# M5 Junction 10 Improvements Scheme

**Applicant Response to Interested Parties D3  
submission**

**TR010063 - APP 9.67**

#### Applicant's Response to Deadline 3 submissions

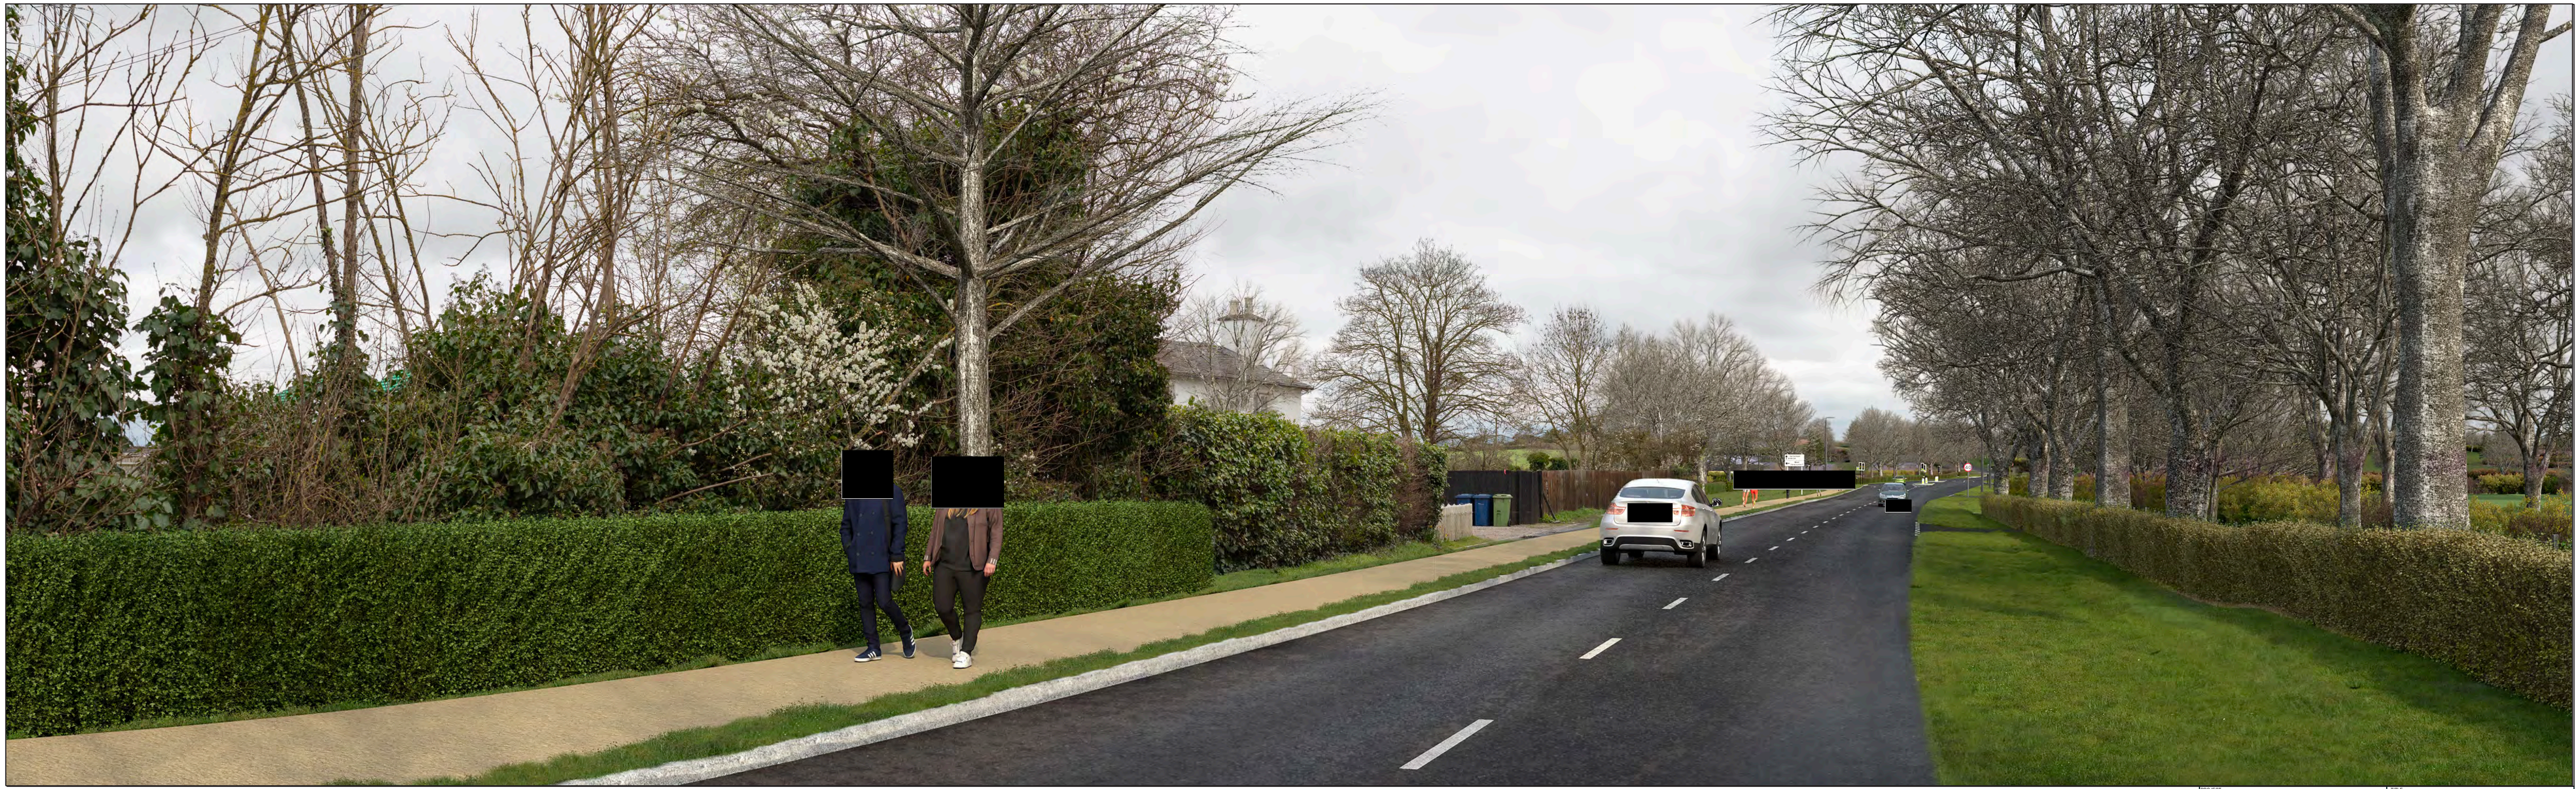
066-05	<p>The visual representations of trees at year 15 appear significantly larger and more mature than one would expect, given that many are depicted as small saplings (under 1 meter) at the outset or as trees less than 2 meters tall. It raises the question of whether there is a documented methodology detailing how these year 15 tree sizes were determined, including annual growth rates, height spread, and trunk size. The projection of most trees reaching heights of 10 metres or more seems overly optimistic, especially for slow-growing species, and does not take into account the limited growth typically observed during the first 2-3 years post-planting. Growth rates are, of course, subject to variation based on environmental conditions, but the visuals seem to represent an ideal scenario. In reality, the trees may not</p>	<p>The visualisations have been produced in order to provide an indication of the form and scale of the proposed engineering works in the context of the existing landscape and townscape. To this end, they have focussed on earthworks and structures and the extent of lost vegetation, with an indication of the soft landscape proposals, based on the DF3 design.</p> <p>Bearing this in mind, the visualisations provide a good indication of how the Scheme can be expected to look. It is not possible to predict exactly how the Scheme will look at year 15 in terms of soft landscape. Plant growth is dependent on factors such as species, spacing, quality of planting and management, soil conditions, shelter</p>

Response Reference	Issue	Applicants Response
	<p>achieve such robust growth. Therefore, it might be more prudent for the visuals to depict a more conservative growth scenario, such as the worst-case or even an average growth rate, to avoid giving a misleading impression. Additionally, it would be beneficial to provide explanations regarding the methodologies used to determine the sizes of trees and vegetation projected at year 15.</p>	<p>and microclimate. The 3D visualisations production team has used a generic 3D model to ensure that they are representing vegetation at assumed heights. For Year 1, heights of 0.6m – 0.8m have been used. For Year 15, heights of 5m –11m have been used (See section 9.15 of ES Chapter 9 (Landscape and Visual Impact Assessment), paragraph 9.15.8)[REP1-016]. The model trees do not show the variety of species proposed and are wider in trunk girth than is likely for year 15 but do provide a good indication of how the proposed planting would provide filtered screening.</p> <p>In developing the visuals, focus was placed on the accuracy of the existing vegetation lost and the proposed built elements. Reworking the visualisations to refine how the planting could look at Year 15 would not add to the understanding of how the Scheme will sit in the landscape over the years. The Year 1 visualisations provide a ‘worst case’ that can be extrapolated over the years. The Year 15 visualisations, are fit for purpose in providing an understanding of how the earthworks, bridges and other built elements will appear in the landscape. The visualisations also indicate how the proposed planting elements will provide visual screening or filtering of the built elements.</p>

066-06	<p>The acoustic fence is depicted as a standard timber structure in all visual representations. However, it is important to note that the final design has not been established. The Landscape and Visual Impact Assessment (LVIA) anticipates that all fencing will incorporate greening elements, such as climbing plants, to soften their appearance and lessen their visual impact. This discrepancy between the visuals and the assessment's description is concerning. Particularly, certain images suggest insufficient space for planting to be successful – for example, Viewpoint 06 shows a minimal gap between the kerb and the fence, which is likely to be filled with the concrete foundations necessary for the construction of both the fence and kerbs. To resolve this inconsistency, it is imperative that either the</p>	<p>The acoustic barrier shown in the visualisation represents a ‘worst-case’ scenario. This is because the manufacturer and exact specification will be decided at detailed design stage.</p> <p>Entry LV6 of the REAC secures the Applicant’s commitment to consult with the local planning authorities and directly affected receptors on options for the final design of noise barriers so that they provide visual amenity and/or biodiversity values as well as noise abatement. In addition, DCO Schedule 2, Requirement 14(1) requires noise mitigation proposals to have been submitted to and approved in writing by the Secretary of State, following consultation</p>

Response Reference	Issue	Applicants Response
	<p>visuals are updated to reflect the greening measures outlined in the LVIA, or the assessment's evaluated impact is revised to align with the current visualisations. Without these changes, the visuals fail to accurately represent the mitigation strategies detailed in the LVIA documentation.</p>	<p>with the relevant planning authority and county planning authority prior to construction. Requirement 14(2)(a) states written details must reflect mitigation measures included in Chapter 6 (noise and vibration) of the ES and Noise and Vibration Management Plan approved as part of the EMP (2nd iteration). The Applicant therefore considers that regardless of the worst case scenario presenting in the visualisations, that there are sufficient controls in the dDCO to ensure sufficient consultation and engagement with relevant parties on the detailed design of these features.</p>

066-07	<p>In the year 1 visuals, the depicted grass areas present a dense and verdant sward, which does not accurately reflect the expected reality. It is anticipated that the majority of these areas will be sown with diverse meadow mixtures that require several years to fully establish. Consequently, during the first year, it is more probable that one would observe considerable patches of bare soil interspersed with only sporadic green growth. The year one imagery, therefore, does not provide a true representation of the greening process for verges and embankments, potentially setting unrealistic expectations for early development.</p>	<p>The Applicant acknowledges the limitations of the current visualisations provided, however, the changes proposed are not considered to add particular value. The visual qualities of the grass verges are not essential to aid understanding of how the Scheme will sit in the landscape and therefore the Applicant does not agree with the request to produce a more detailed sward representation.</p>

066-09	<p>The hedges depicted in the visuals do not seem to represent the native hedgerows proposed accurately. They are presented as being quite</p>	<p>As per the methodology detailed in para 9.15.8 of the ES Chapter 9 (LVIA) [REP1-016], the Applicant has used a height of 0.6-0.8m for</p>

Response Reference	Issue	Applicants Response
	<p>diminutive, even at 15 years of growth, which contradicts the expected development. Furthermore, the image suggests a uniform species, neatly trimmed hedge, which is a departure from the diverse and natural appearance suggested in the landscape proposals. The proposals likely envision a more robust and varied hedgerow that would typically include a mix of native plant species, contributing to local biodiversity and offering a more authentic representation of the natural landscape.</p>	<p>Year 1 hedges and 1.2m for Year 15 hedges. It is acknowledged that the hedges could be considerably taller than this, however, it is anticipated that the hedgerows are likely to be maintained to a 1.2 or 1.5m height, as they are currently.</p> <p>Although the hedges shown in the Year 15 visualisations are presented as neat and uniform, the Applicant does not consider this to affect the function of the visualisations to aid in the understanding of how the Scheme will sit in the landscape.</p> <p>The hedges are proposed to be species rich, and underplanted with wildflower grass as appropriate, thereby providing enhanced biodiversity and visual interest.</p>

Drawing Title: **LAND PLANS REGULATION 5(2)(i) SHEET 13 OF 16**

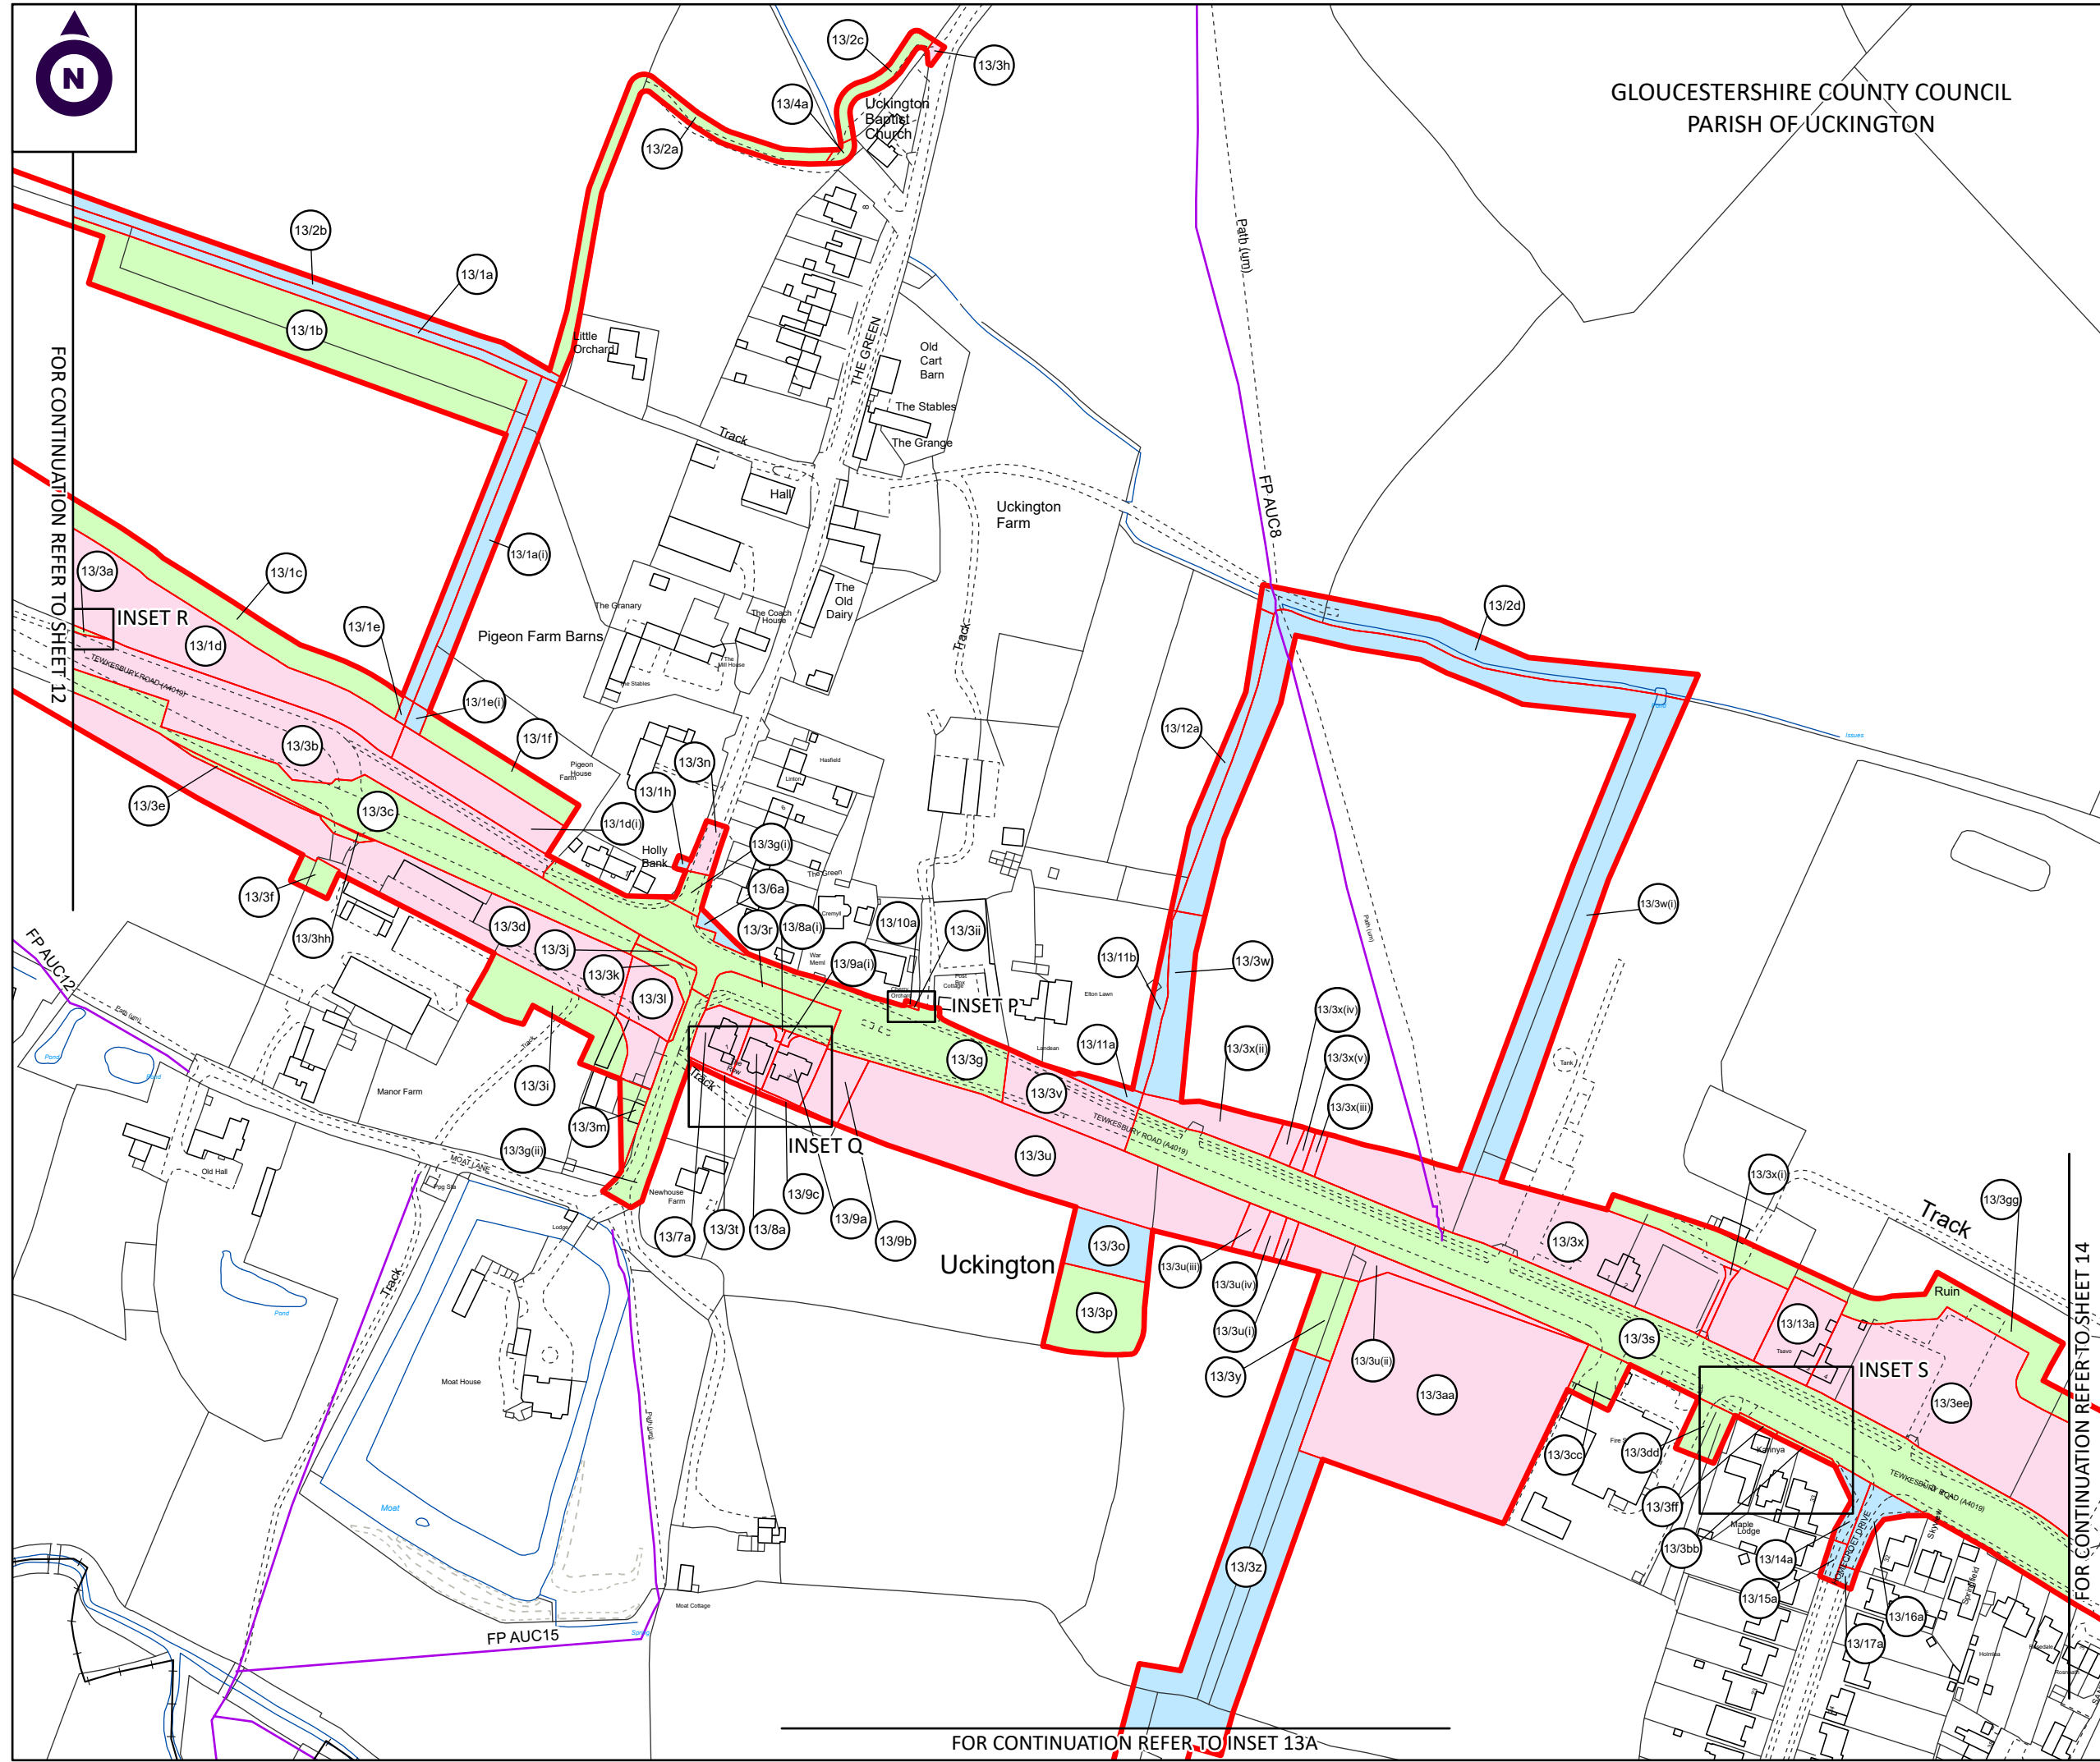
Response Reference	Issue	Applicants Response made at D3 – APP 9.44
12.1	<p>We have some concerns over access to a river gauging station during the works at Uckington.</p> <p>If I refer you to Sheet 13 of 16 (TR010063-000742-TR010063_2.2_Land_Plans), we would normally use the A4019, Moat Lane and then a track to access our asset (please see EAAssetUckingtonPlan.pdf), however it looks as if the works will prevent this access.</p> <p>We are not accessing this asset frequently, however, therefore if we could be provided with the dates of work, then our team believe we would be able to work around this.</p>	<p>Please note that the Applicant has received and responded to this issue previously.</p> <p>The Environment Agency raised this issue first in relevant representation ref. REP2-012, to which the Applicant responded in ref. REP3-044.</p> <p>A copy of the response provided in REP3-044 is provided below:</p> <p>The Applicant understands that the site at Uckington is not currently a working Environment Agency river gauge but a concrete trapezoidal channel that was once intended as a new gauge for the River Chelt.</p> <p>The proposed Scheme will not prevent access to this site on the River Chelt. The Applicant is not undertaking any works on Moat Lane in the vicinity of the Environment Agency’s access point.</p> <p>The only issue on access are the works planned to the A4019 and the junction of the A4019 and Moat Lane at Uckington which will require temporary traffic management measures. However, access to Moat Lane will be maintained not least due to the need to ensure access to residential properties along Moat Lane is secured. Access to residential community and business premises is secured within the Traffic Management Plan which is in turn secured via requirement 3 of dDCO.</p>
